Appeal Decision

Appeal Ref: APP/R5510/D/24/3339069

114 Northwood Road, Harefield, Hillingdon, UB9 6PS

- The appeal is made under section 78 of the Town and Country Planning Act 1990 against a refusal to grant planning permission.
- The appeal is made by Mr Liam Halpin against the decision of the Council of the London Borough of Hillingdon.
- The application Ref 20106/APP/2023/3090, dated 24 October 2023, was refused by notice dated 8 January 2024.
- The development proposed is extension to existing loft conversion to include hip to gable conversion – installation of rear dormer and two number front roof light windows and front porch.

DRAWING TITLE: PROPOSED ELEVATIONS

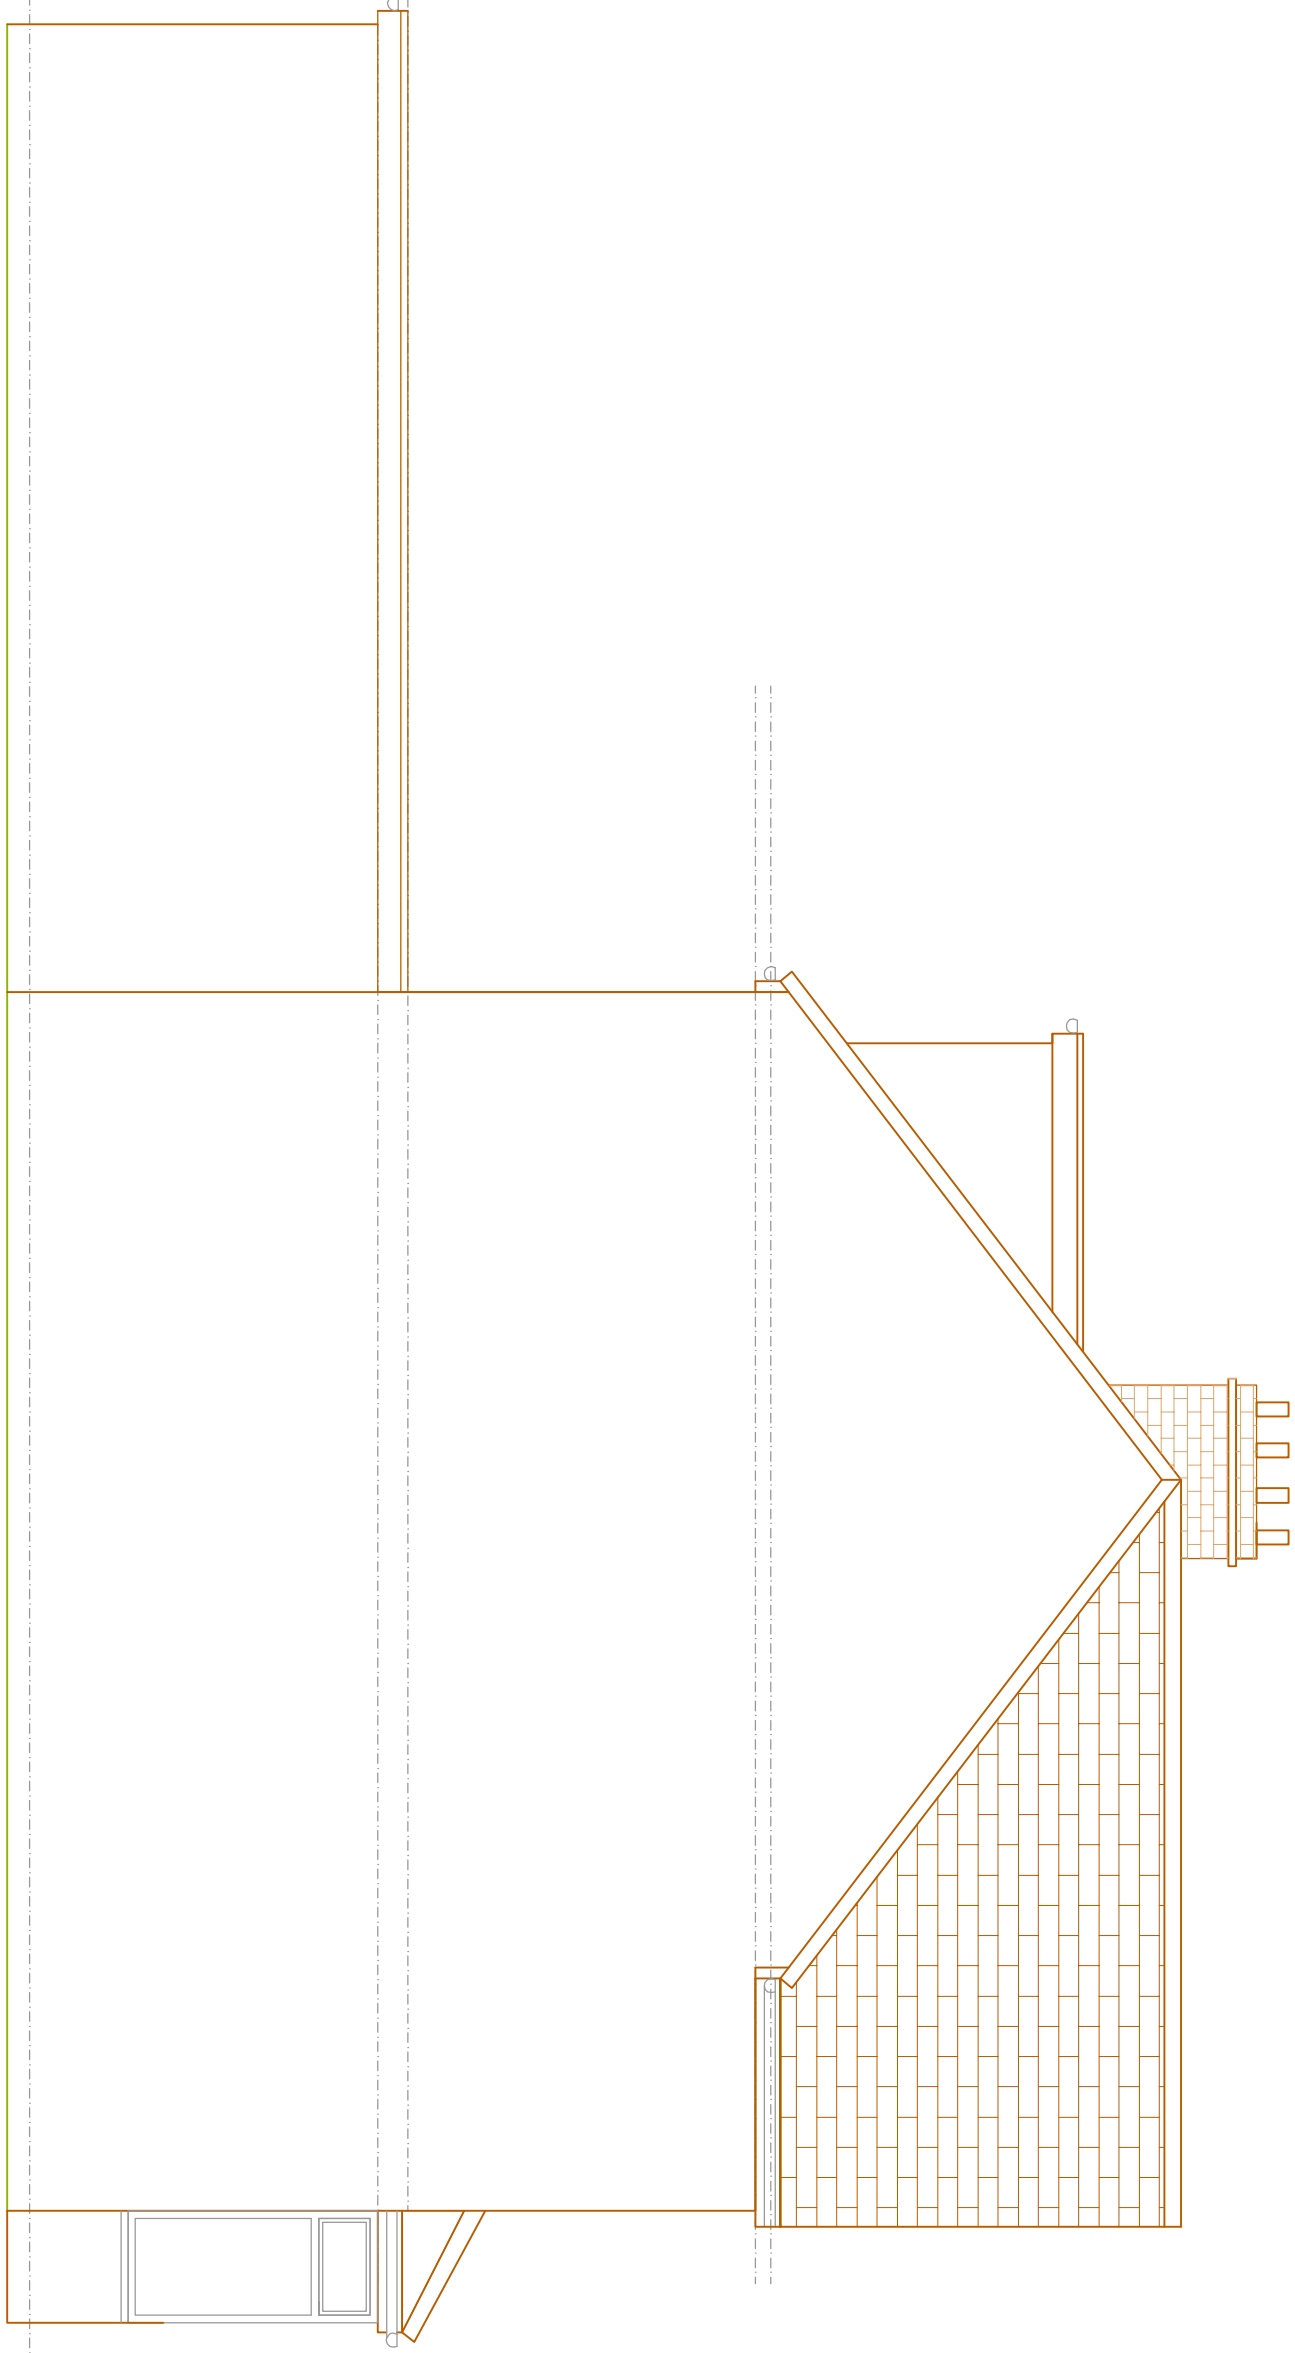
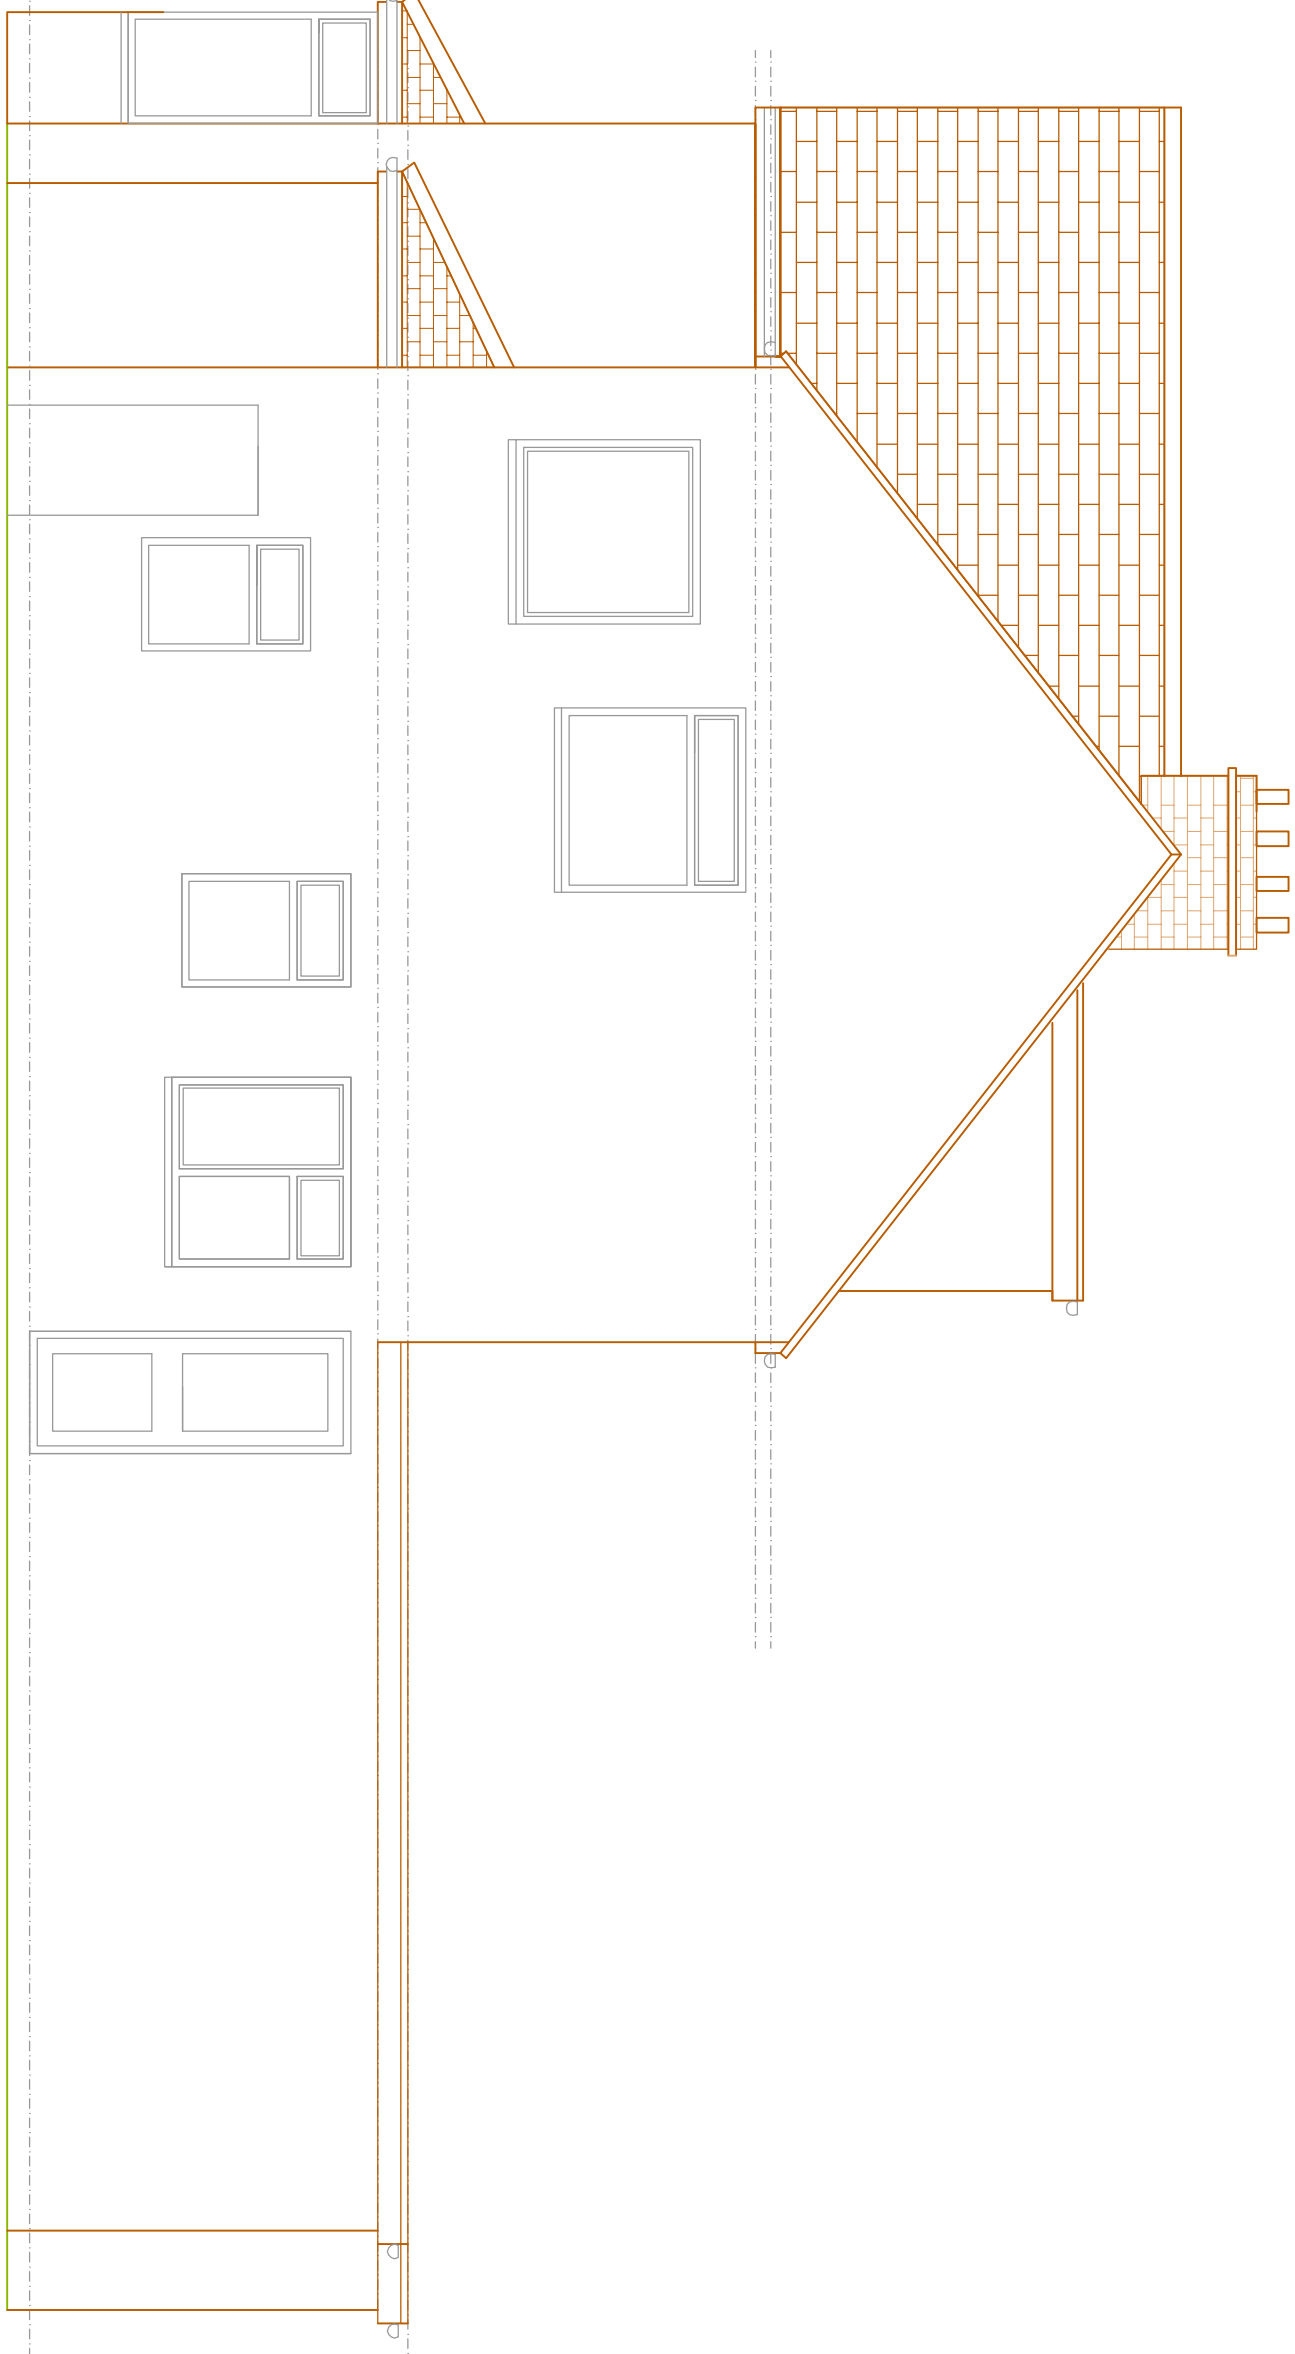
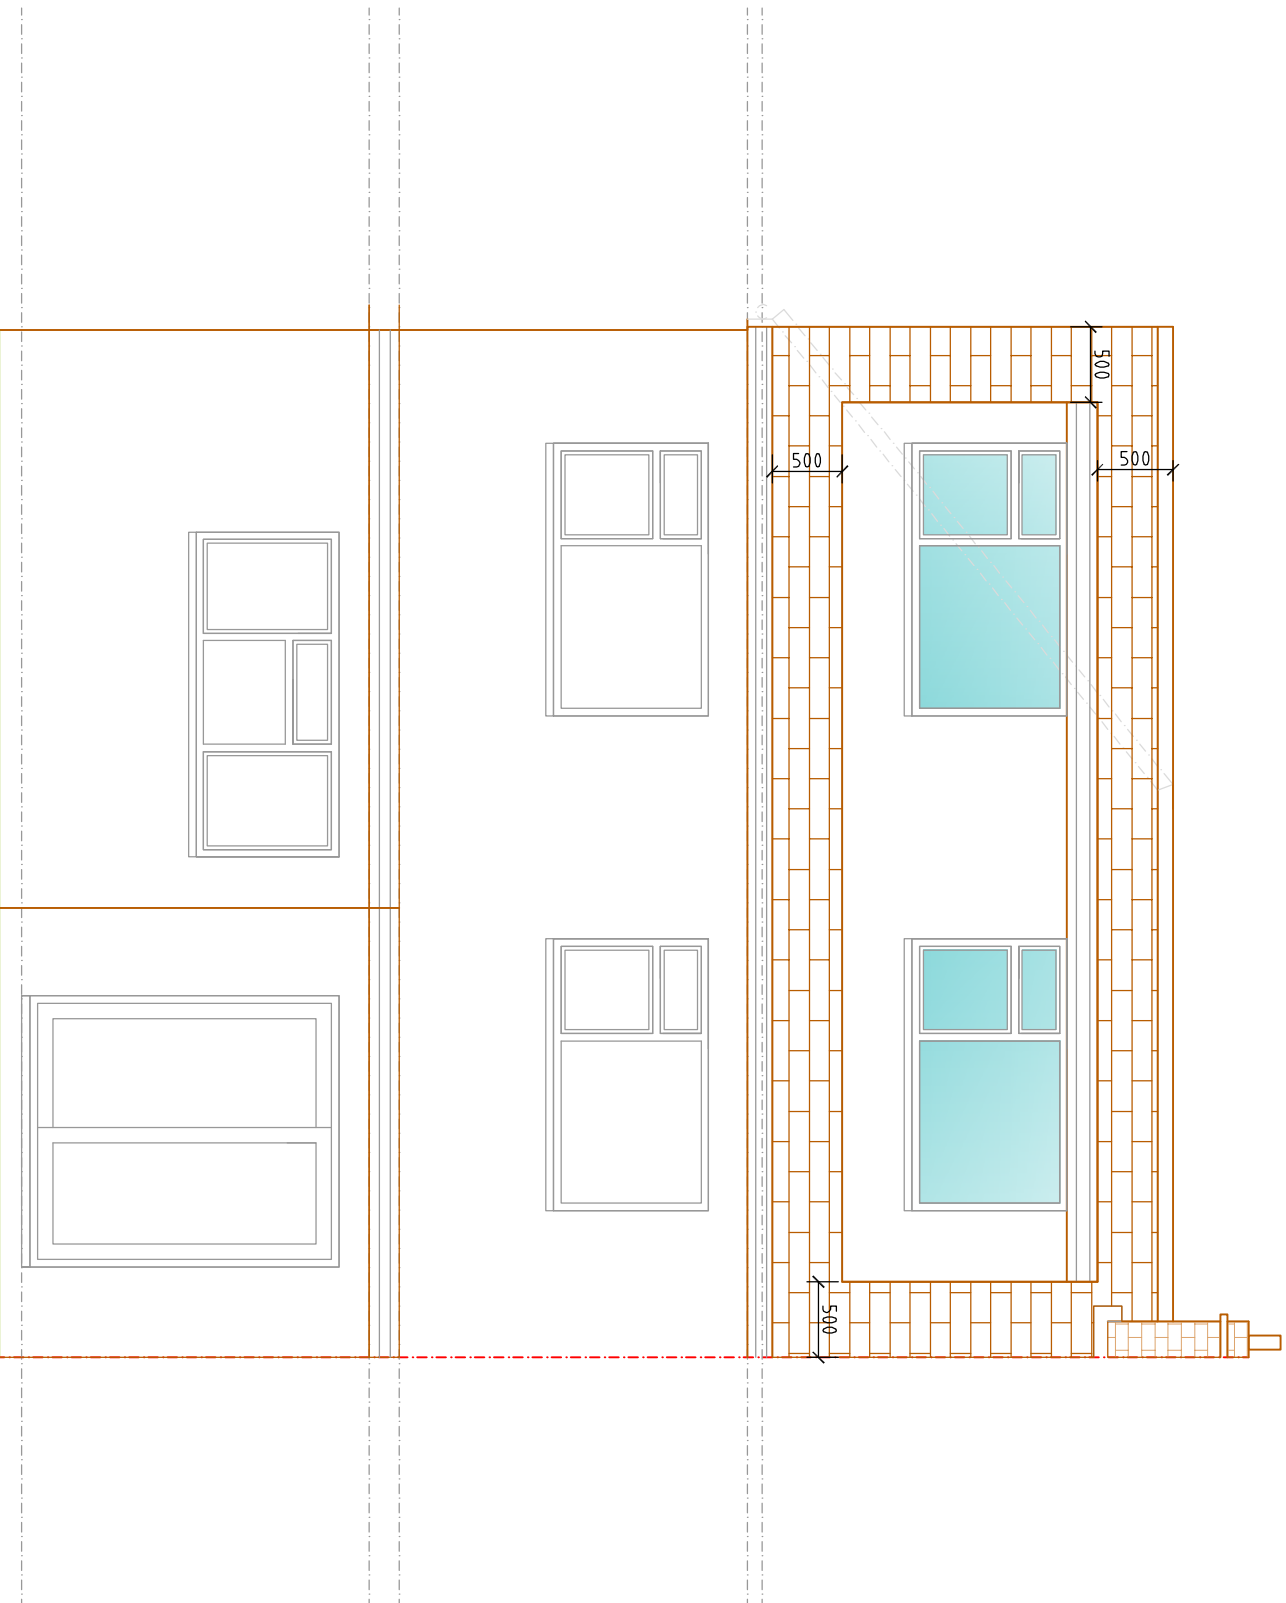
5. The proposed extension to the roof space would result in a new gable element replacing the existing hipped roof. It would be over that part of the building which is set back from the main front gable which is shared with the adjoining semi-detached house, No. 116, and which dominates the combined frontage of the building as a whole. Although it would alter the existing composition and symmetry of the building, I consider that it would integrate with the appearance of the building. It would not result in a disproportionate increase in bulk and its scale would be in keeping with the varied house styles along the street. There would be no increase in height above that of the main ridge.

6. I consider that the design of the hip to gable roof is appropriate in the context of the general character of the surrounding area. It would be set back from the main front gable and would not result in an over-large extension. There would be no adverse cumulative effect on the character and appearance of the street scene where there is a variety of roof forms, including a similar example further along the street to the east.

7. The proposed rear dormer, although out of proportion with the existing roof, would be set away from the ridge, eaves and sides of the new roof and in proportion with it. It would exceed two thirds of the width of the original roof but the window glazing would be aligned with that of the first floor windows below. Although overall the dormer would be larger than the guidance in policy DMHD1, it would not be readily visible from public viewpoints and this element alone would not be sufficient to justify dismissing the appeal.
